DRB CASE ACTION LOG (SITE PLAN B.P.)

DRB Application No.: 05DRB-00558 (SBP)

Project # 1003919

Project Name: PARADISE SKIES UNIT 5

City Project No.	730902	Zone Map No.	A-11	Sheet	1 of 3
------------------	--------	--------------	------	-------	--------

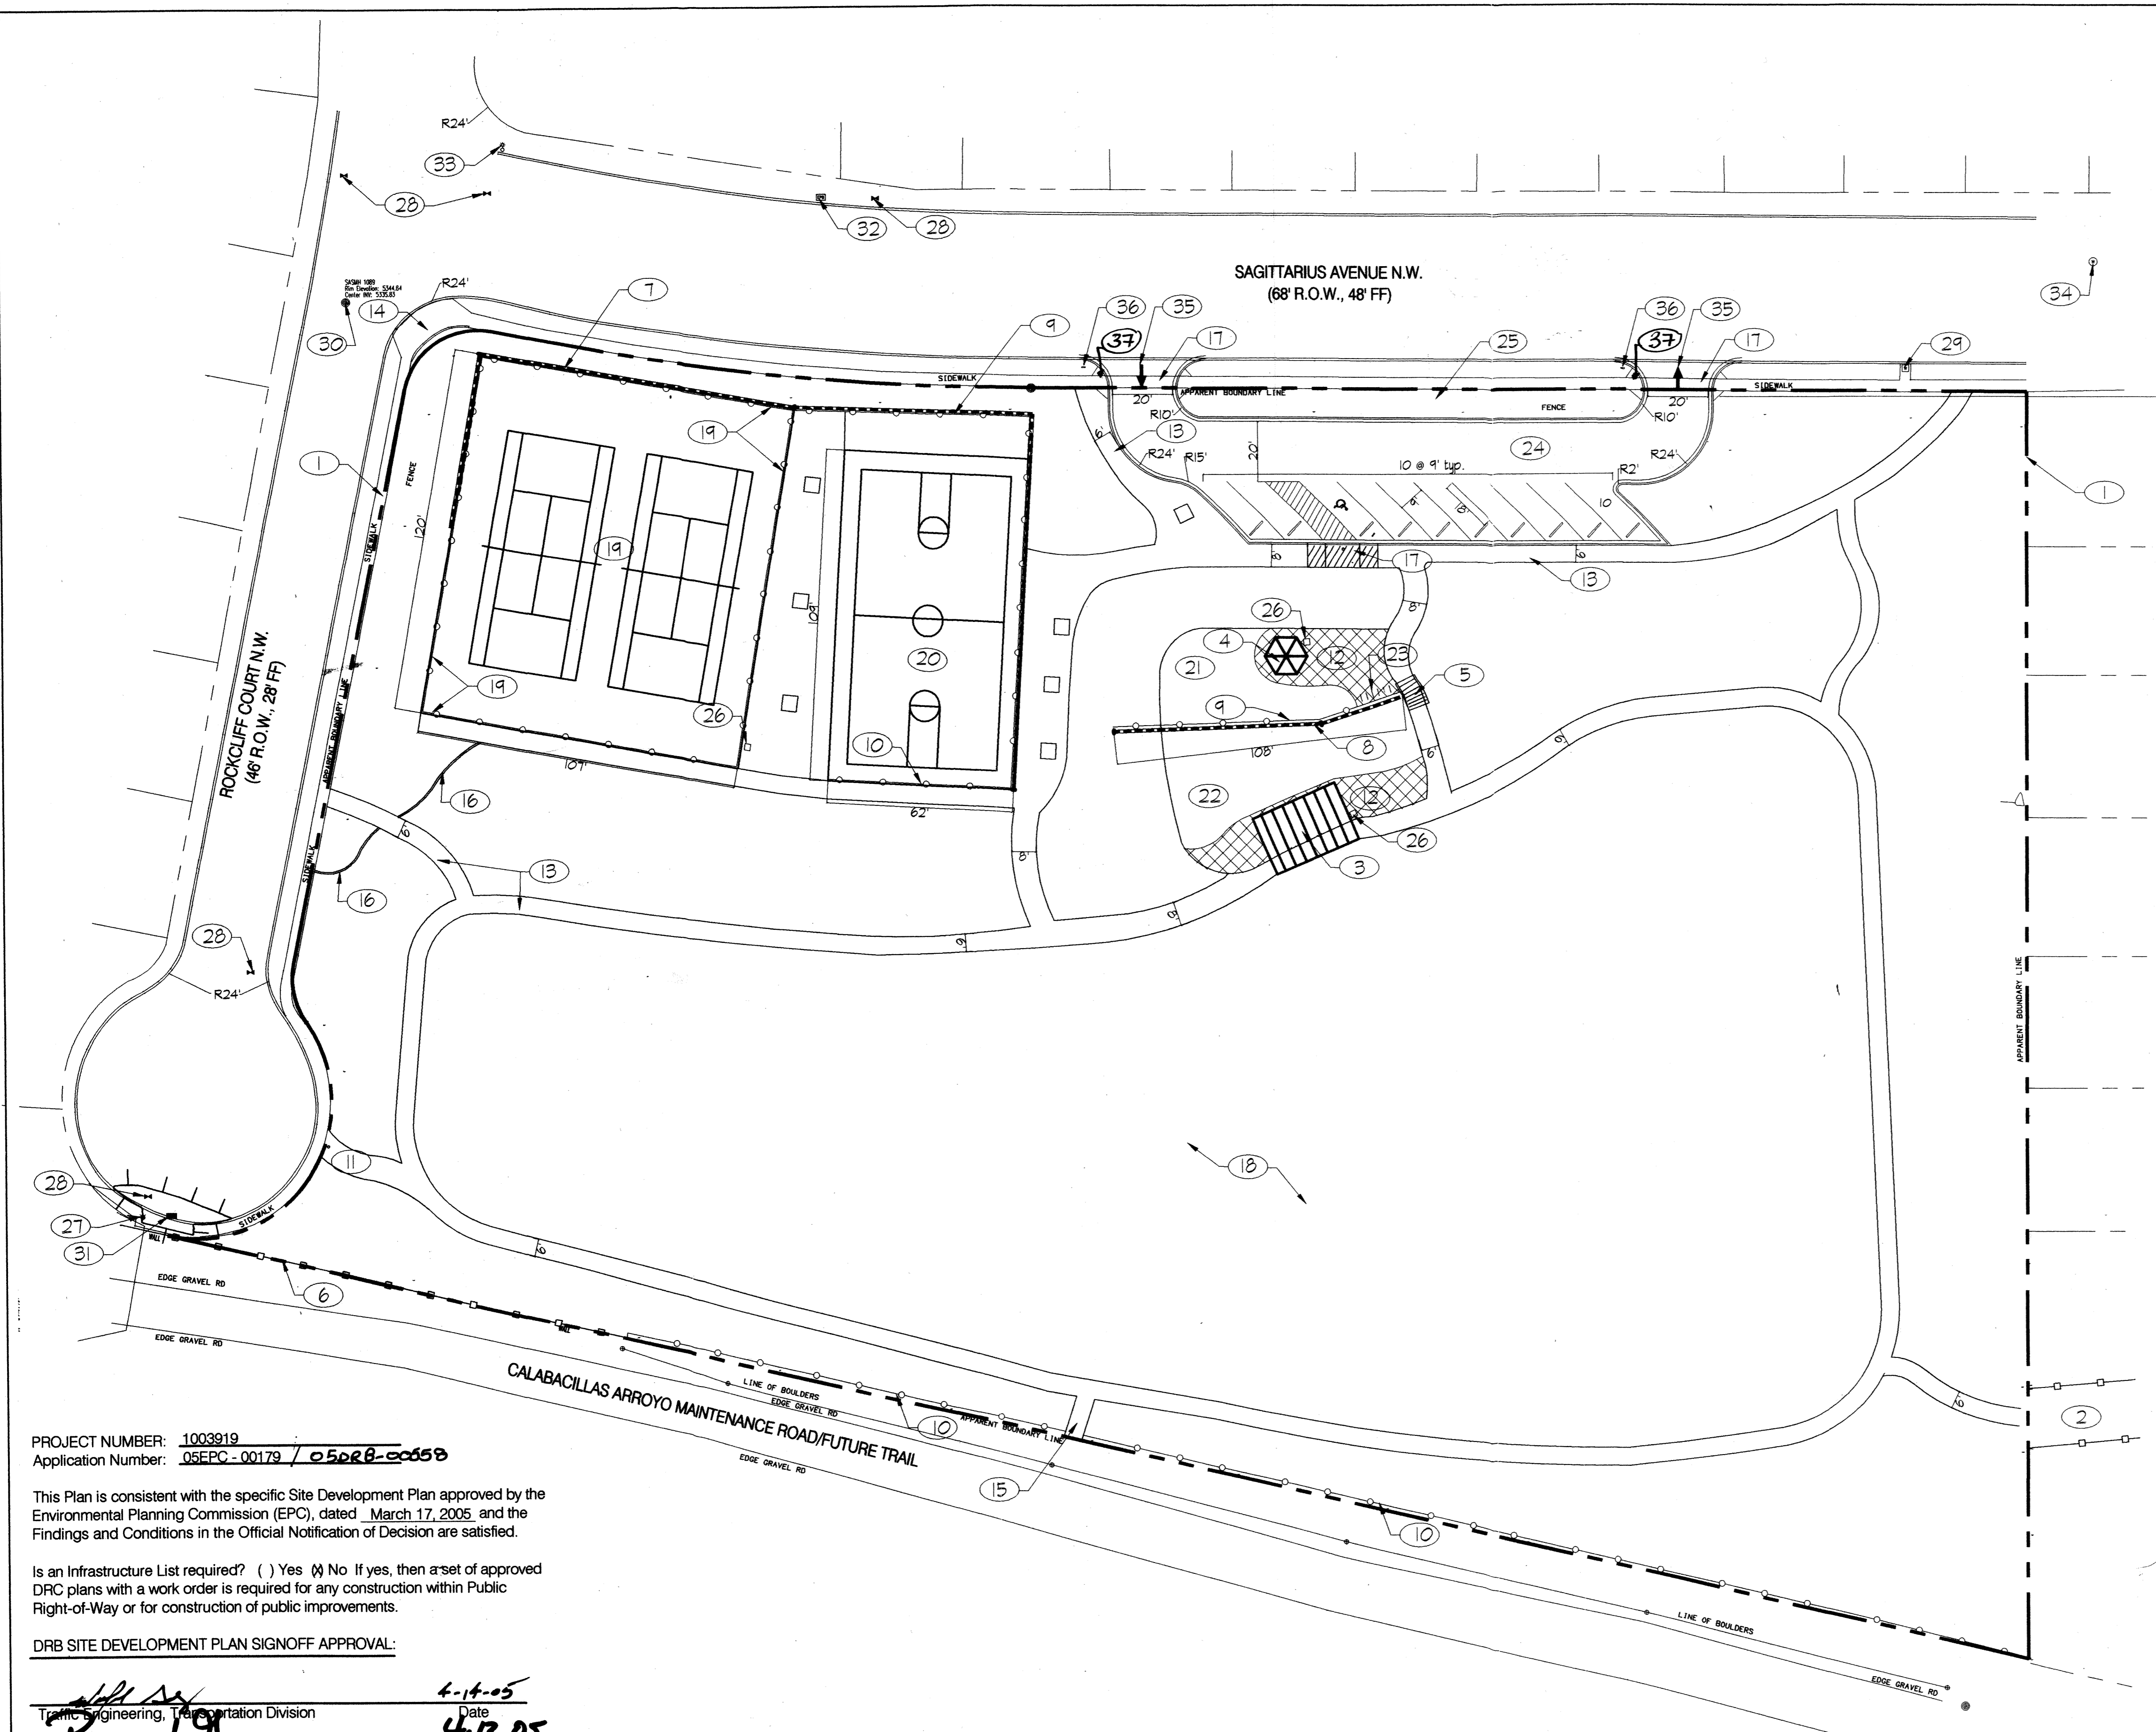
TRANSPORTATION: NOTED CITY STANDARD PUBLIC R/W'S FOR APPROVAL WITHIN PUBLIC R/W. ✓ OK WR

TRANSPORTATION: Need CITY STANDARD PUBLIC R/W'S FOR ROAD WITHIN PUBLIC R/W.
